## **BUILDING CODE OF AUSTRALIA REPORT**

**Mixed Use Development  
Site 9 – Sydney Olympic Park**

## BCA ASSESSMENT REPORT

Corner of Olympic Boulevard and Sarah Durack Avenue, Olympic Park - Site 9

**General Arrangement Plan  
Level 08**

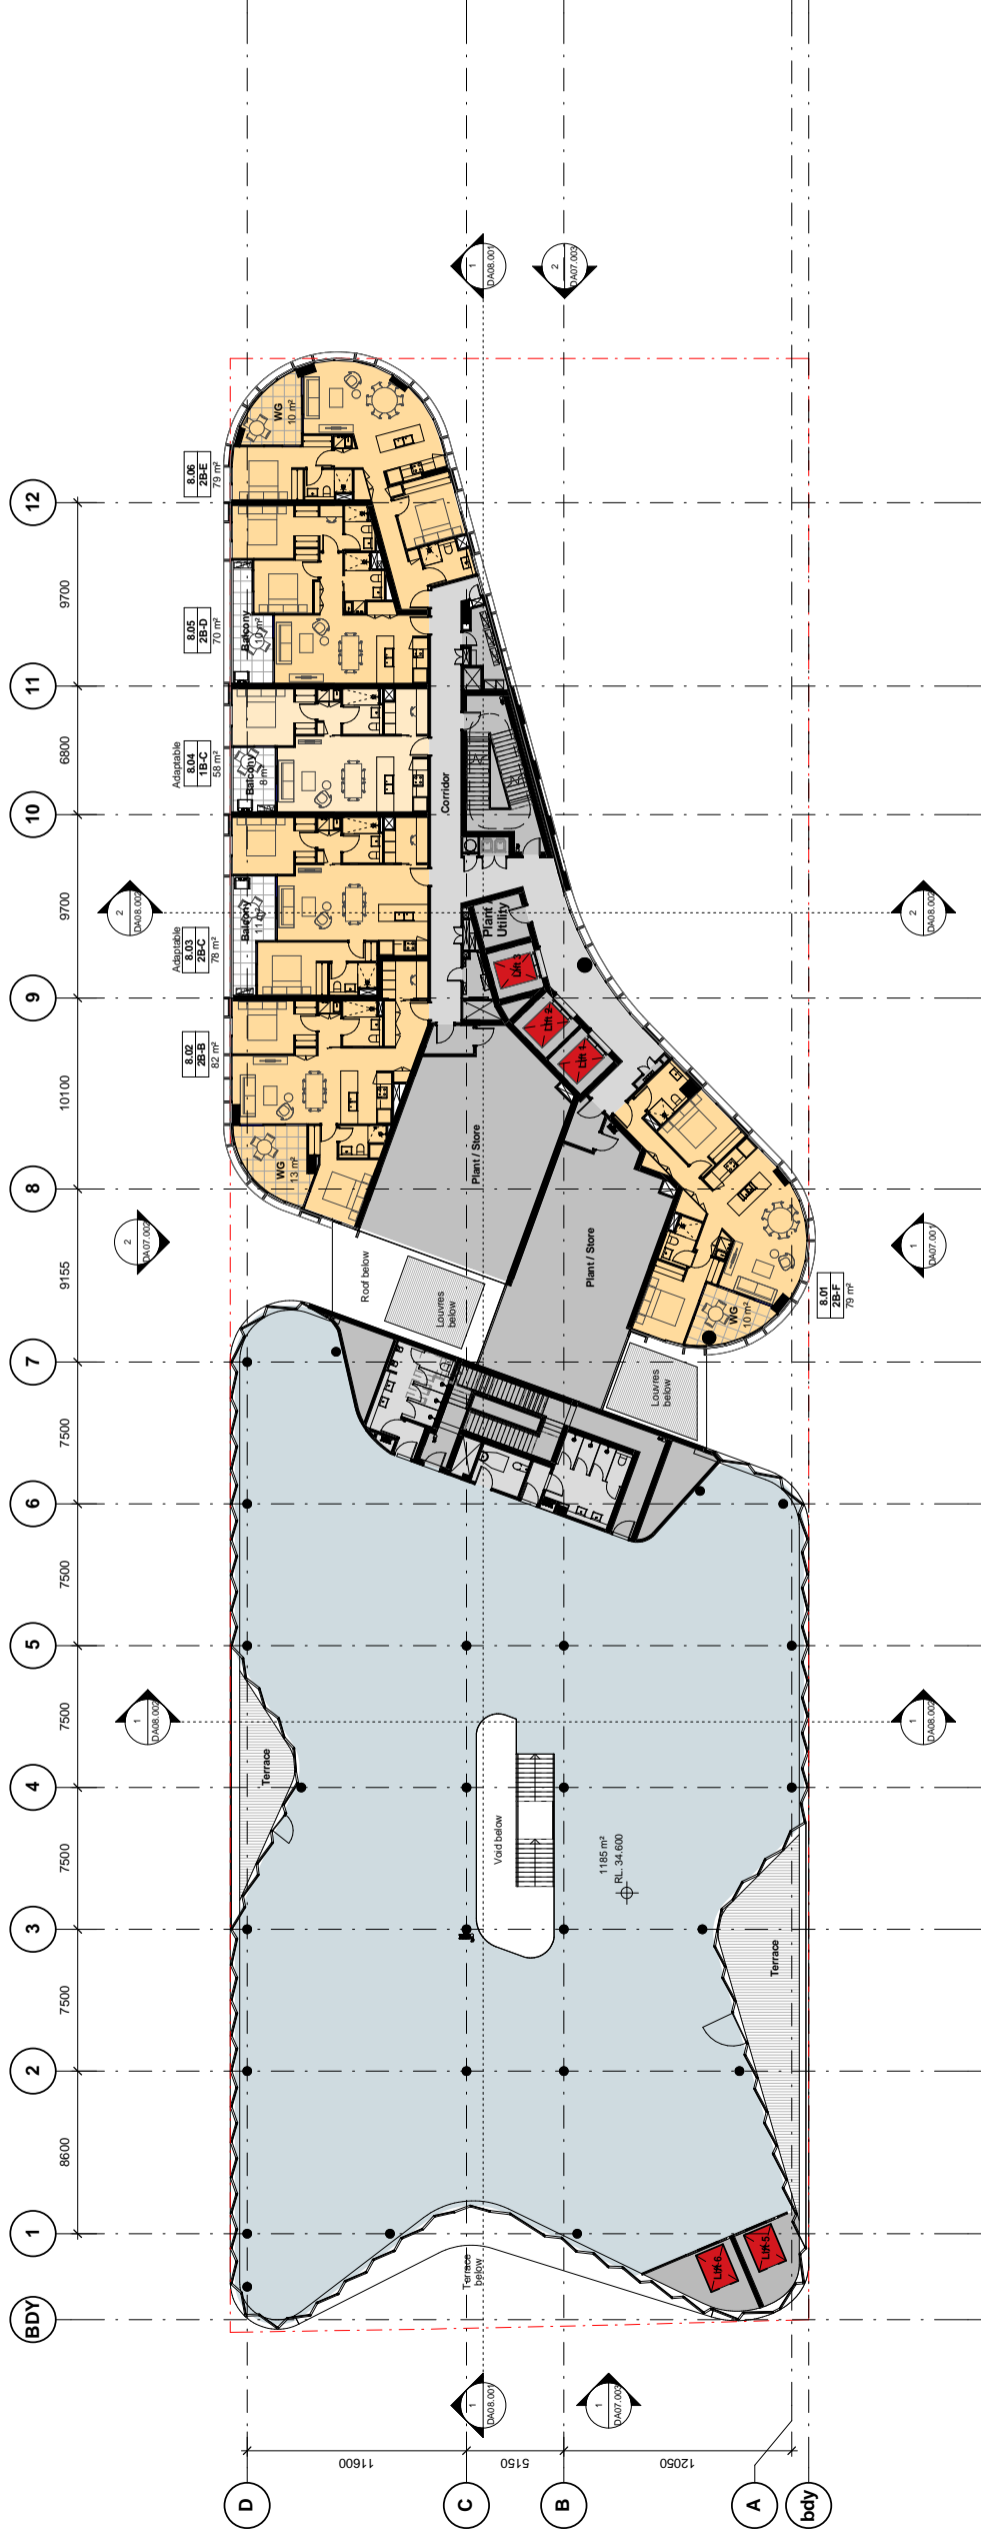
- Travel distance is up to 48m in lieu of 40m where 2 exits are available (this is without fixtures being detailed which will increase the travel distances)

- Travel distance is up to 27m in lieu of 20m from within non-SOU area.
